CITY OF MERCER ISLAND

February 16, 2021

RE: DSR20-010 & SEP20-005 Request for Information 1, 7833 SE 28th St--*revised*

1 SITE PLAN  
1" = 10'-0"

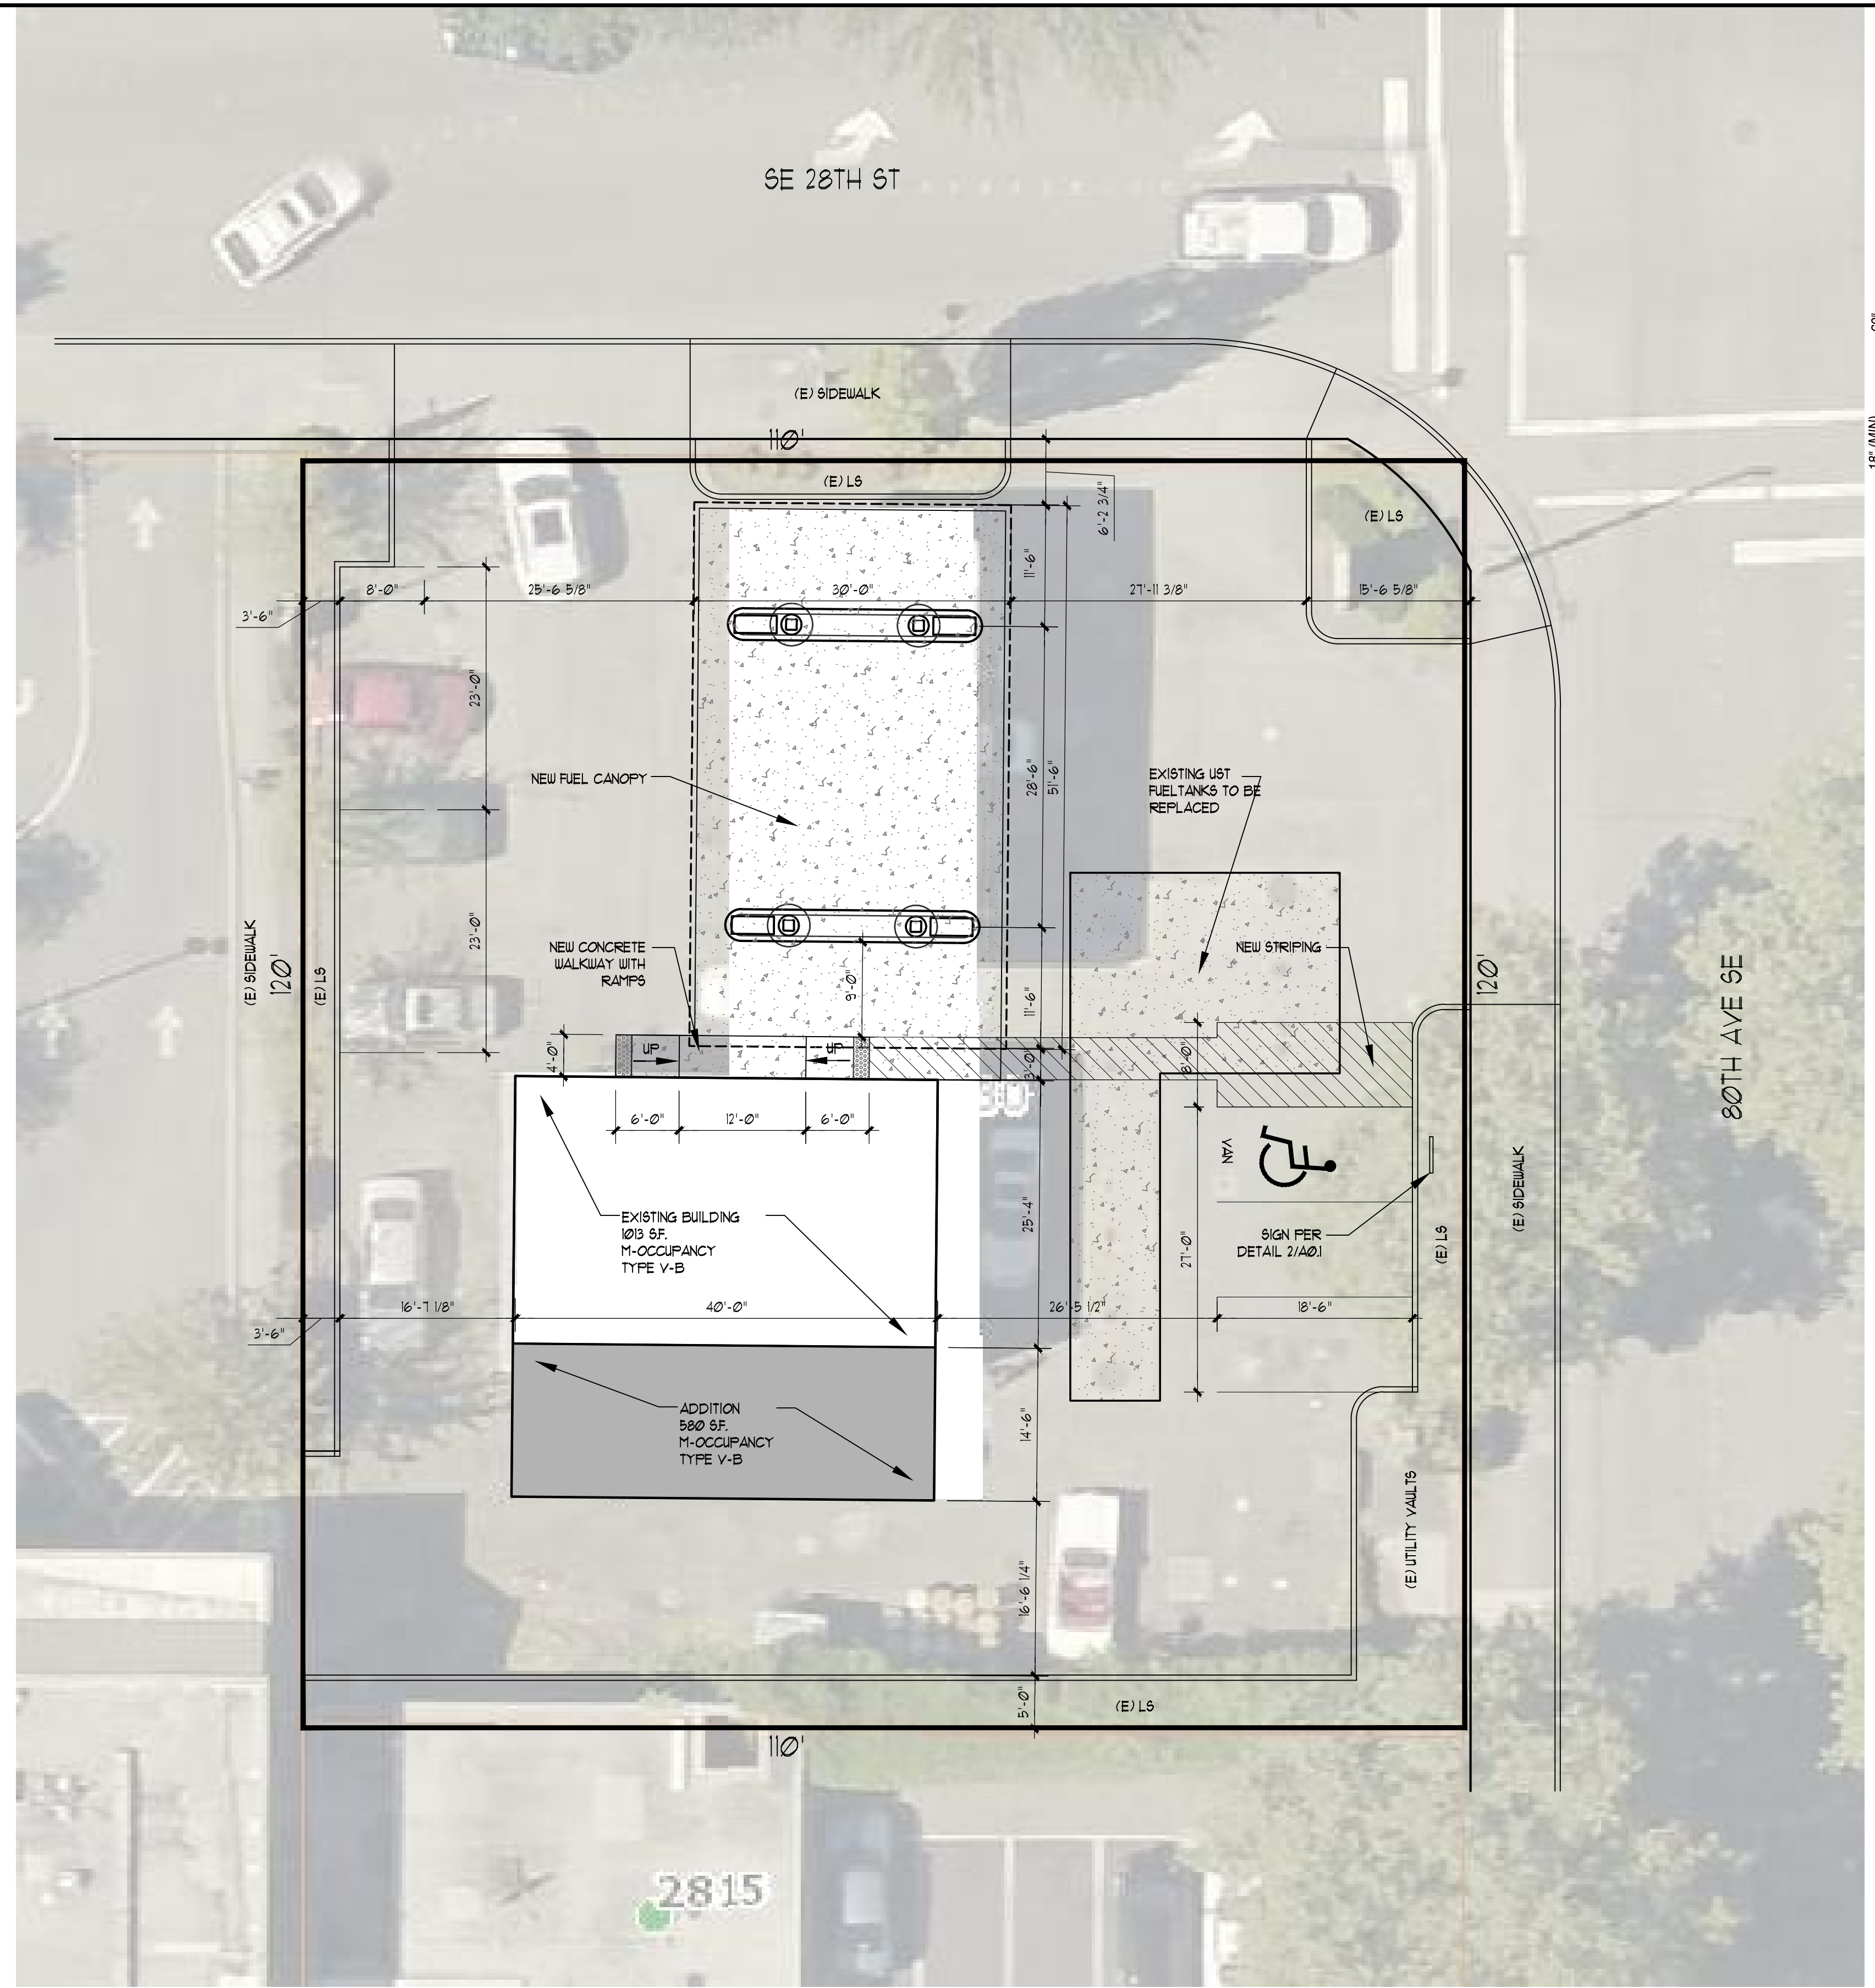
4. Please document how the parking standard in MICC 19.11.130 are met, even with the addition of new retail area.
5. Please describe the how issues raised in the comment letters from the Department of Ecology and Puget Sound Clean Air Agency will be addressed.

2 EAST ELEVATION  
 1/4"=1'0"

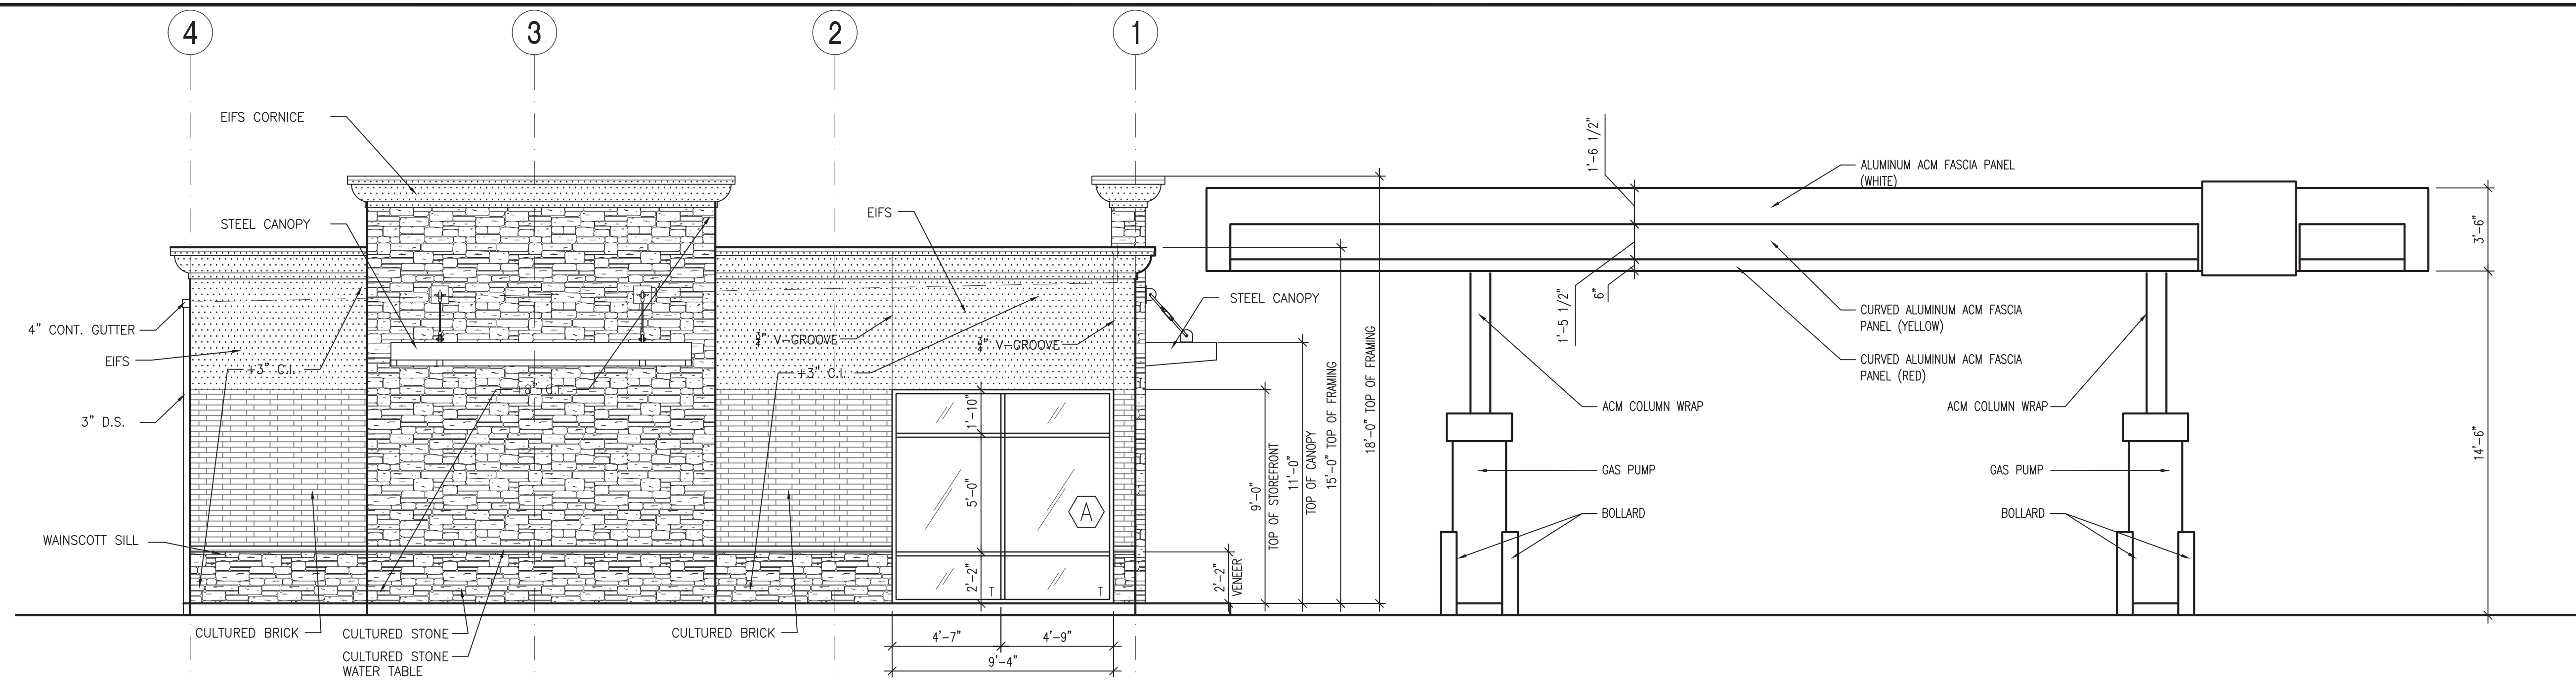
2. Sheet A2.1 shows a blank wall on the east façade that exceeds the size allowed by MICC 19.11.100(B)(5). Please revised the design to meet this standard. (Note that MICC 19.11.100 encourages transparent facades; adding transparency would be a way to fulfill both code standards.)

FIGURE 3
 SITE PLAN

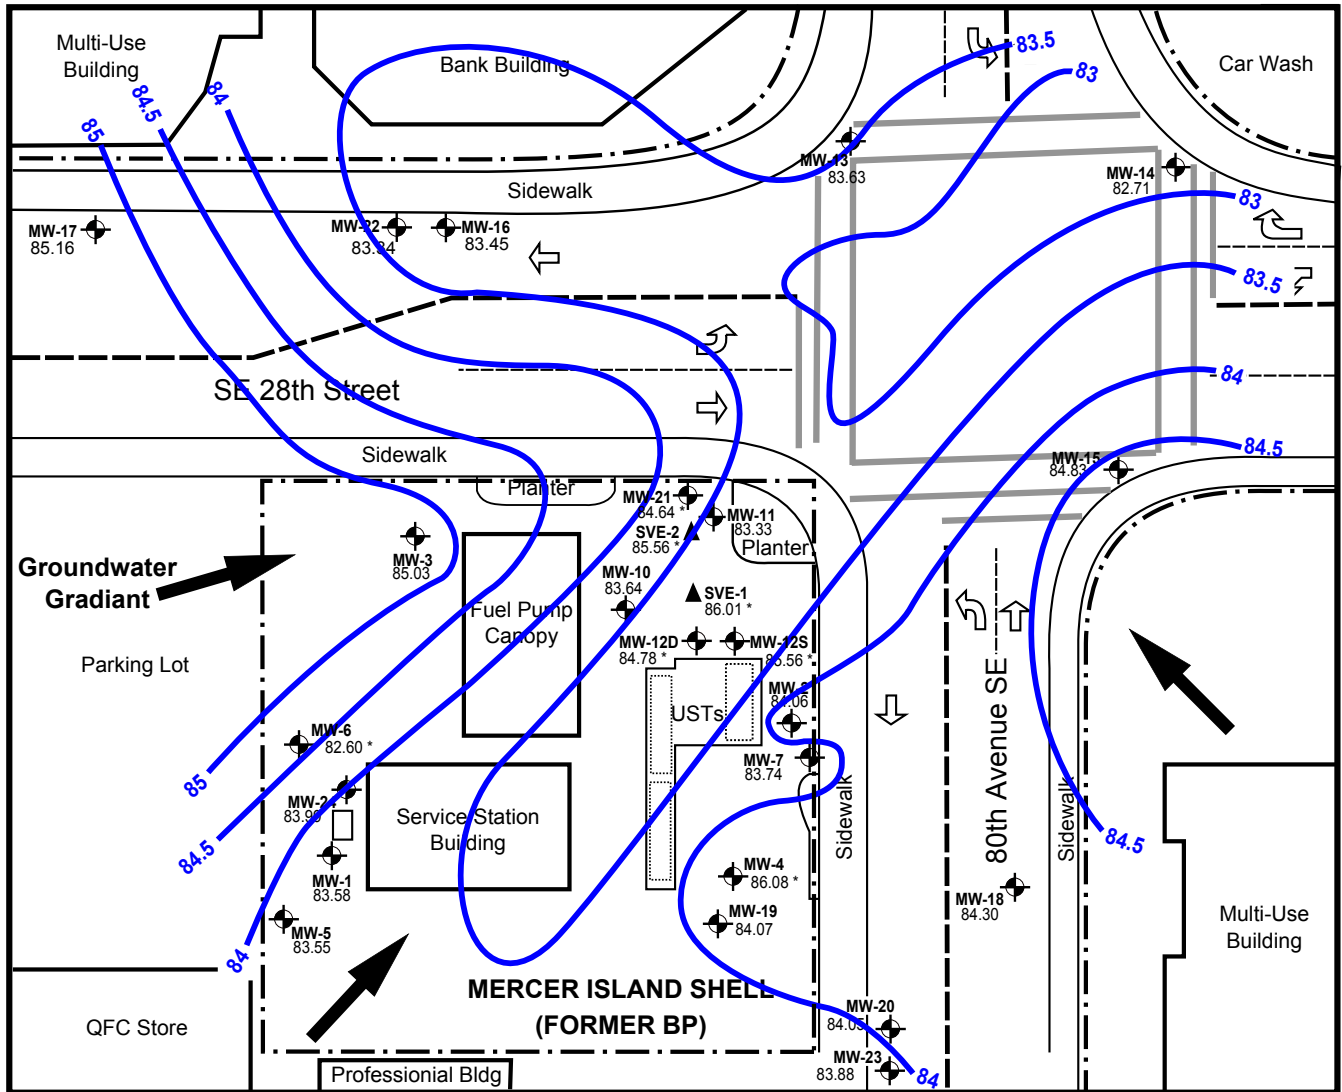
- at least two of the cited figures (Figures 3 and 4) show that the extent of the groundwater plume impacted by both gasoline and benzene extend well into the City’s right-of-way on both SE 28th Street and 80th Avenue S.E.
